**TOWER 2, LEVEL 23
DARLING PARK, 201 SUSSEX ST
SYDNEY NSW 2000**

RESPONSE TO SUBMISSIONS (BUILT HERITAGE) SUPPLEMENTARY LETTER - LINDFIELD LEARNING VILLAGE

The purpose of this letter is to provide comment from a heritage perspective on the proposed construction staging within the previously proposed development. This application seeks partial development consent for the school.

DEVELOPMENT APPLICATION

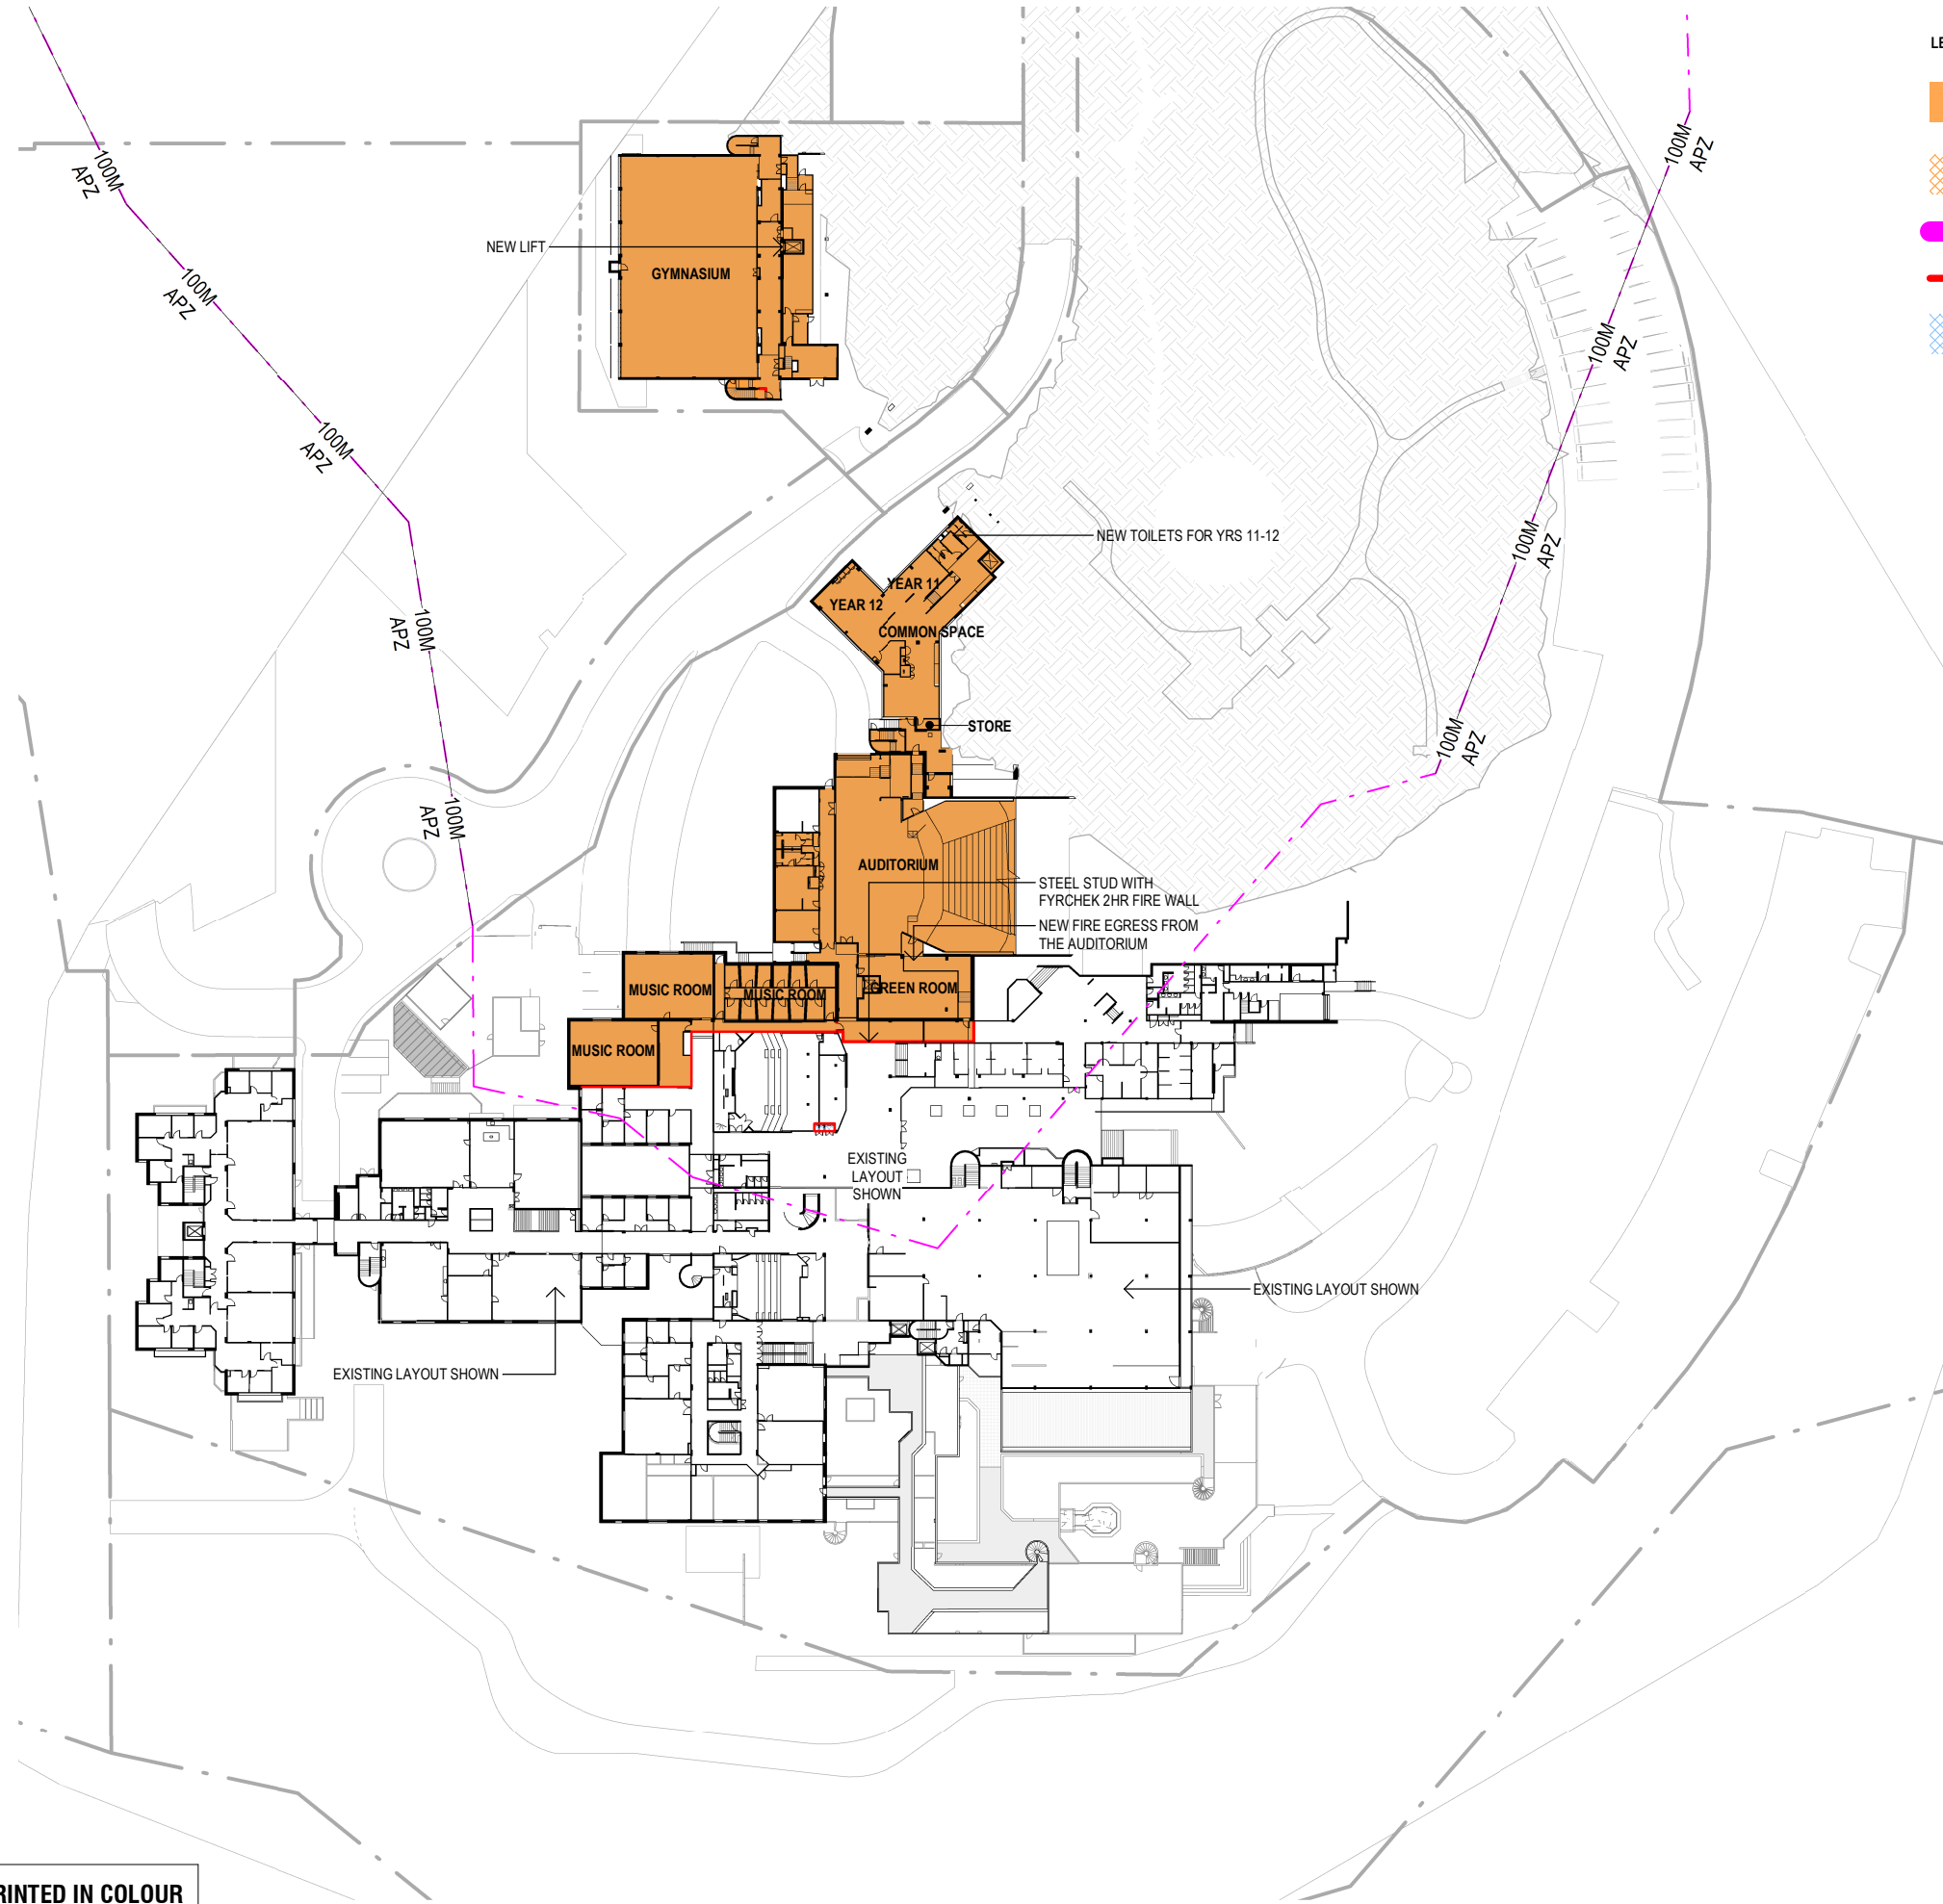
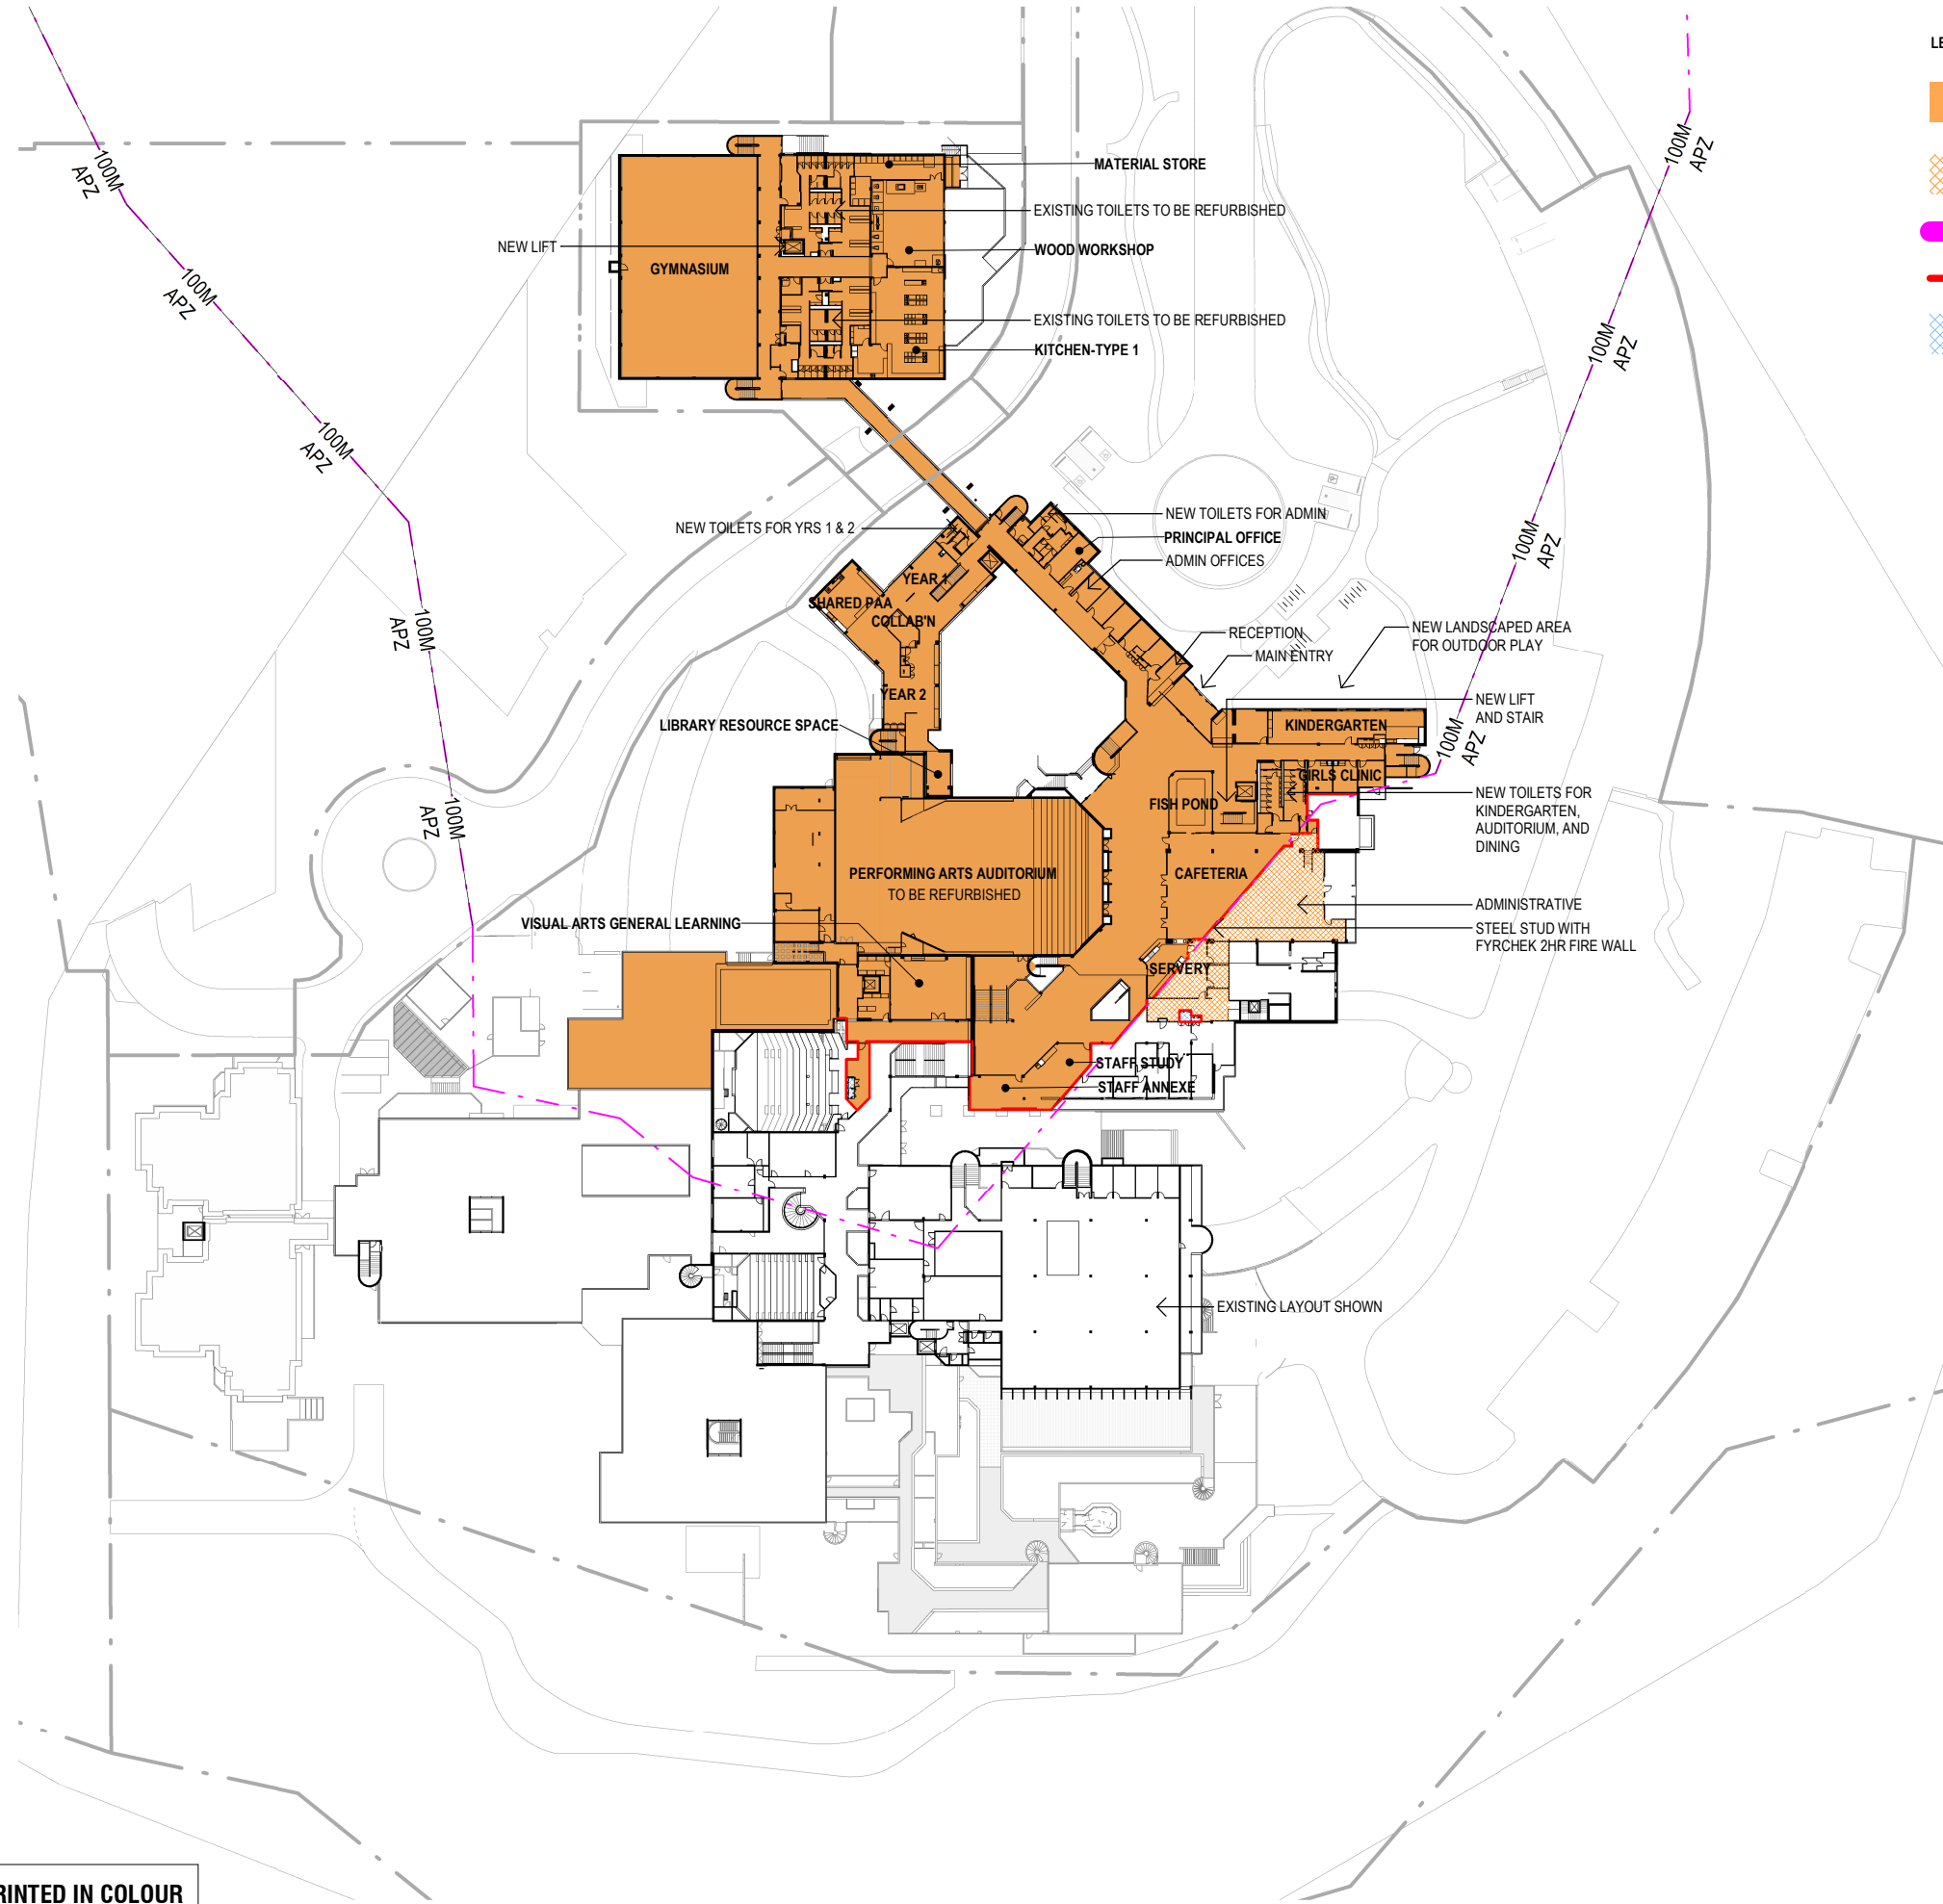
There is a fire wall proposed on the alignment of the fire protection zone.

The fire wall would intersect key spaces including the cafeteria and may present as an ad hoc addition. It is however recognised as a necessary measure to ensure the school is able to function in a limited capacity by 2019 and is therefore an acceptable impact.

It is recommended that a methodology be prepared for the construction of the wall which ensures that it is reversible. This would ensure that the southern portion of the school can be seamlessly incorporated into the Phase 1 school pending an appropriate bushfire resolution. It also ensures that there would be no permanent impact on the building should the remainder of the school not be reused, and the Phase 1 school vacates the site in the future.

- Complete tree removal is proposed under this application as a 'worst case scenario'. To mitigate some of the negative heritage impact of denuding the site of all trees Urbis strongly recommends that the number of trees for removal be considered carefully and minimised as much as possible.
- A methodology should be prepared for the installation of the fire wall in conjunction with the heritage consultant such that it is entirely reversible.
